Case Officer: Hannah Kersley
Reference: FP/46/22/T
Location: 25 Lindsey Court, Felpham, PO22 8JQ
Proposal: 1no. ash tree - remove 2.5m branch overhanging neighbouring property
Reasons given: None provided

Mark Warwick
Tree Officer / Greenspace

Ash Pruning
Date August 2021
Scale 1:200 1:1250

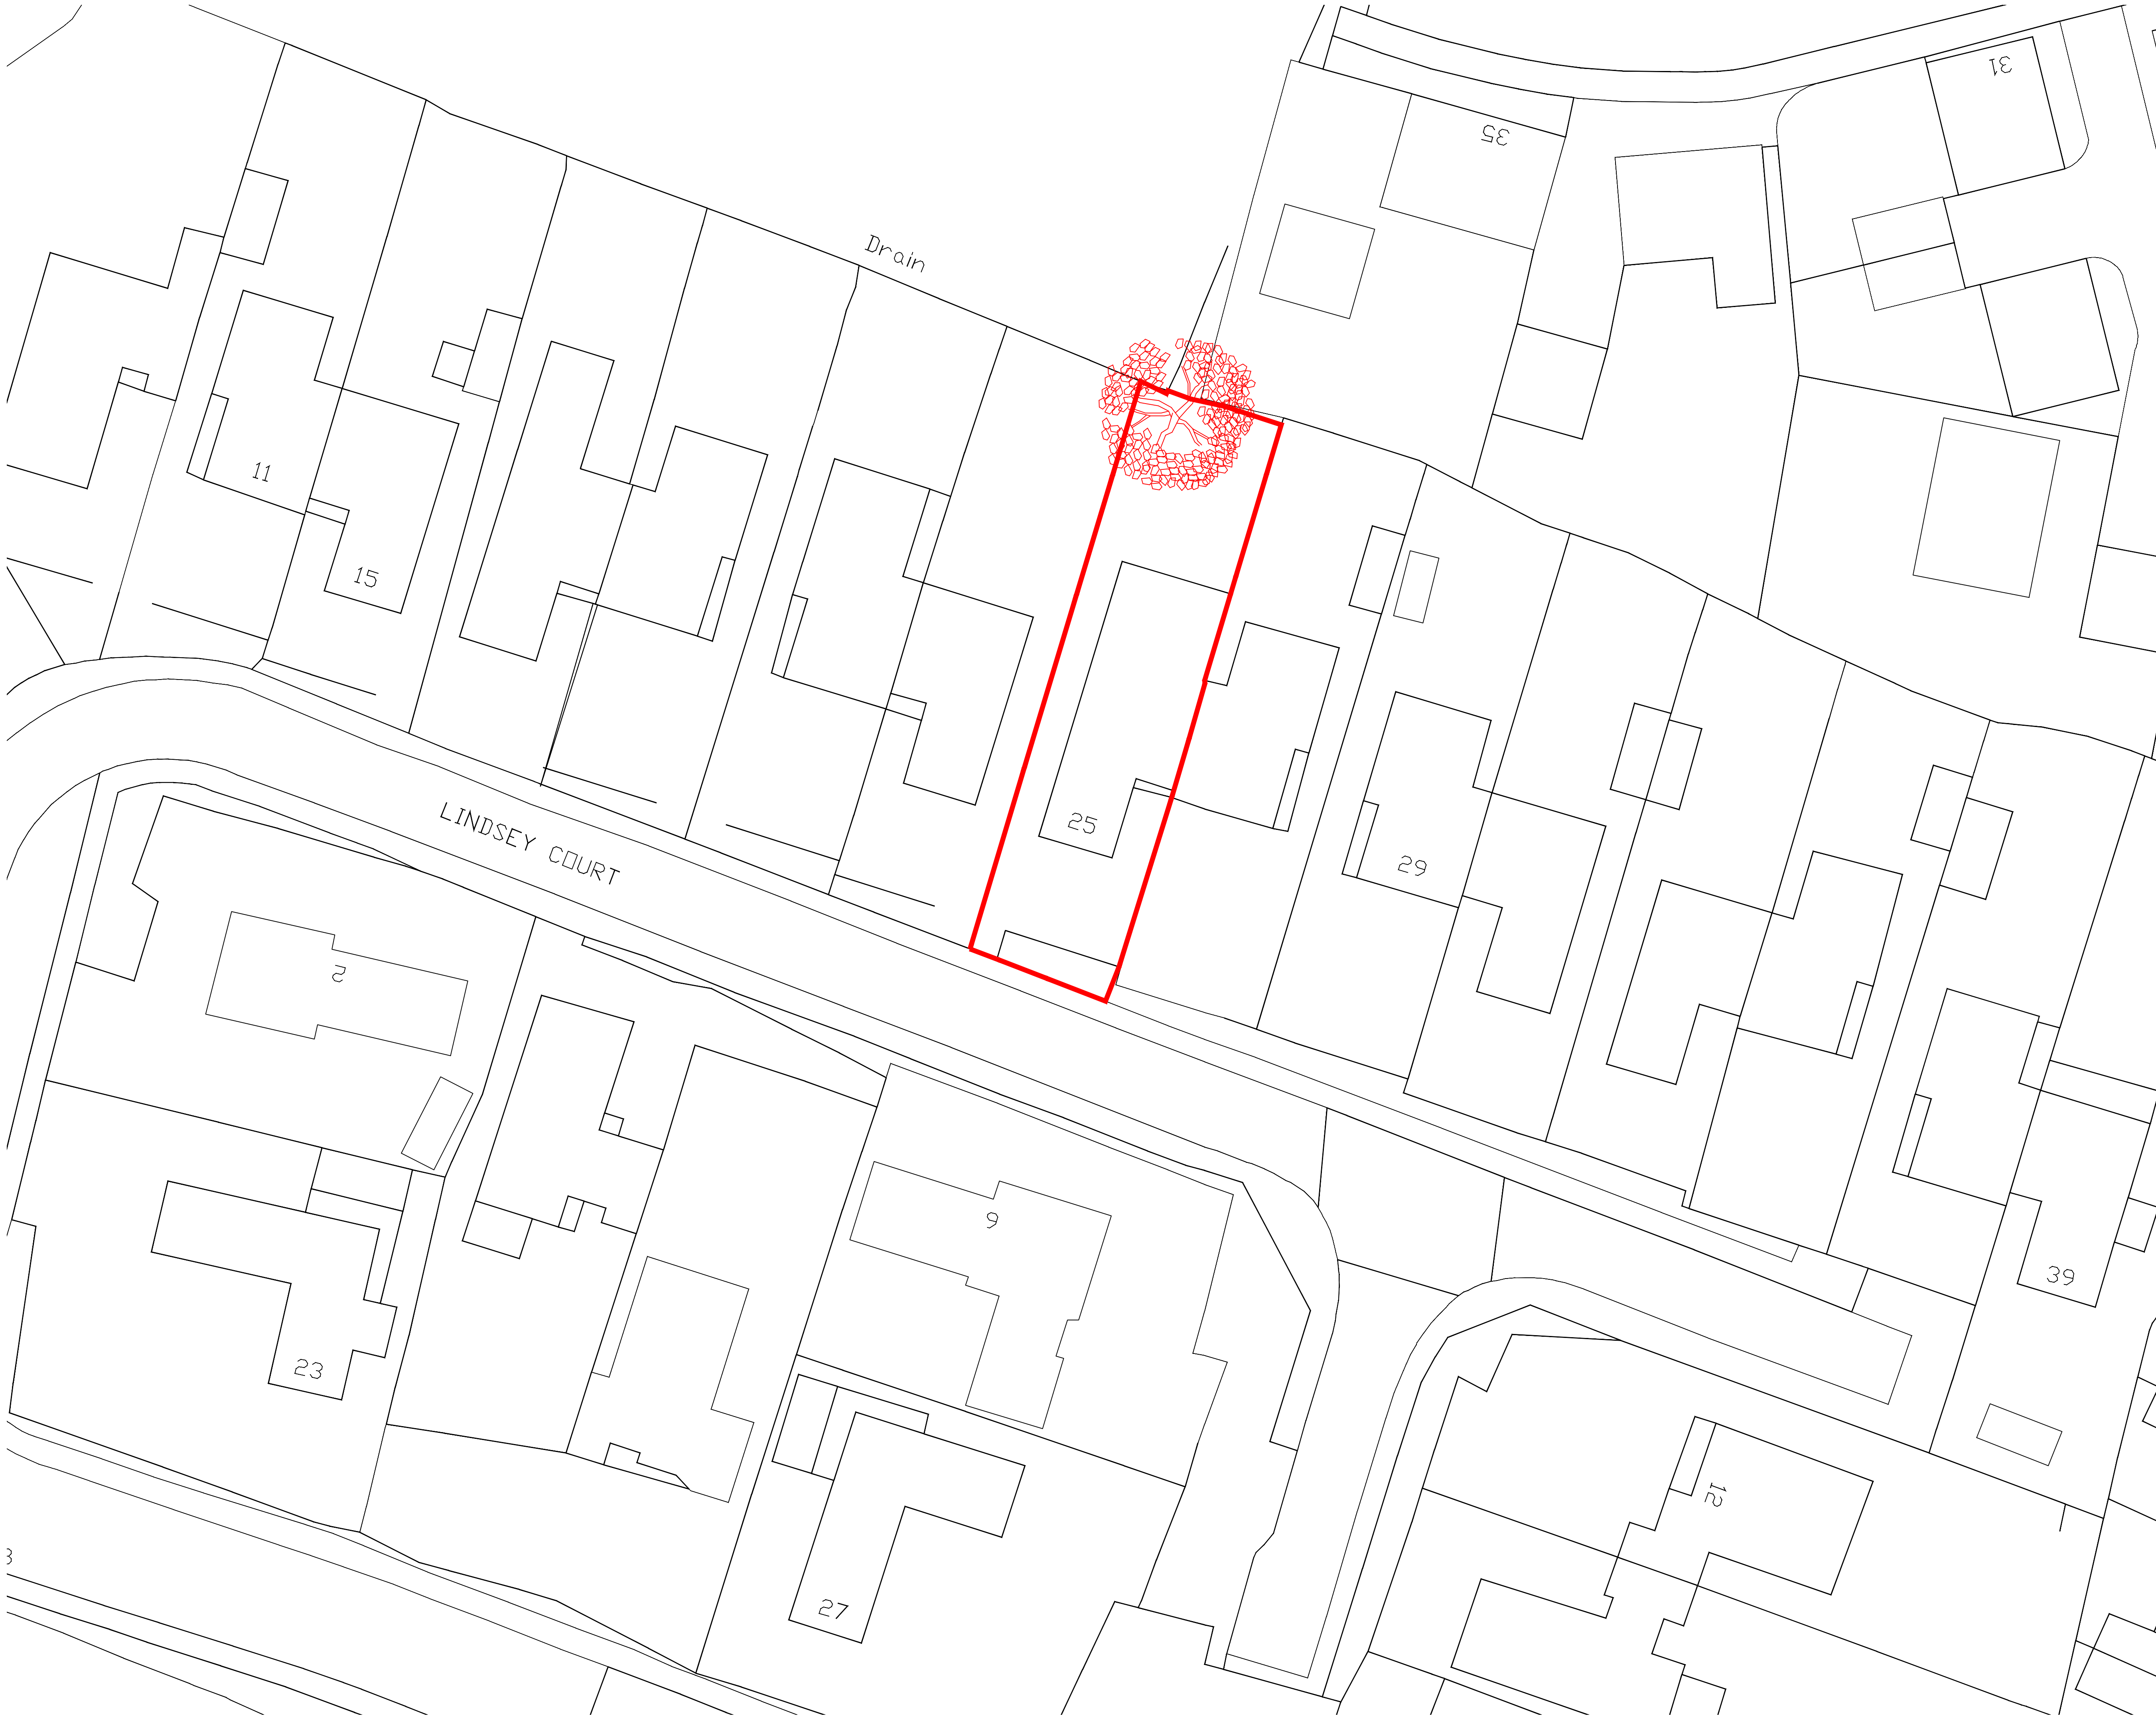
- I have considered this application by means of a desktop review, using the information and plans submitted as well as online resources.
- The tree appears to be in a fine physiological state and assumed to be so in the absence of any evidence provided to the contrary. It is visible from surrounding properties and to users of the public highway.
- Its crown overhangs several rear gardens. Although the work specification is ambiguous, the photographs suggest that lateral spread only on the west aspect (overhanging 23 Lindsey Court) is to be affected. No height reduction is proposed. The application is determined on this basis.

- I recommend **CONSENT** is granted subject to the following condition:

Part a) Where whole branches are to be removed and final cuts made close to the trunk or branch union they are to be made as shown in Figure 2 of BS3998:2010

Part b) Where branches are to be shortened back the final cuts are to be made at the correct angle shown in BS3998:2010 and adjacent to a live bud or lateral.
